40, West Street

Planning Application Number BR/214/18/PL

Drg No: **RNHB.PLAN 2**

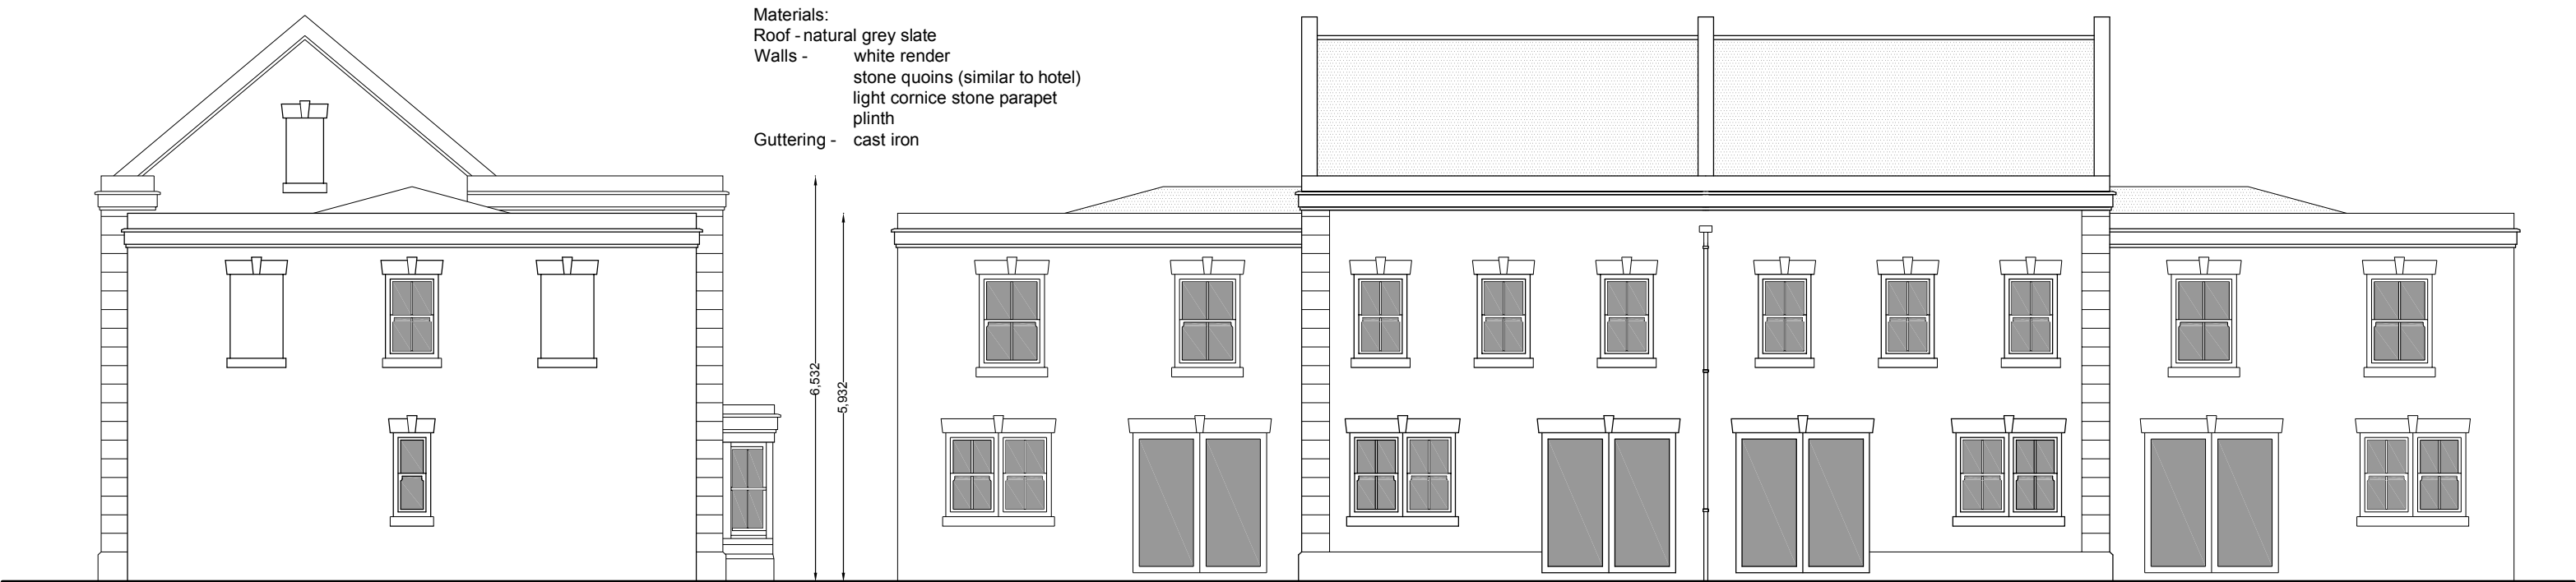
The new buildings are planned to be 2 stories with an additional bedroom in the roof on 2 of them, which makes it much too high for this side of the street.
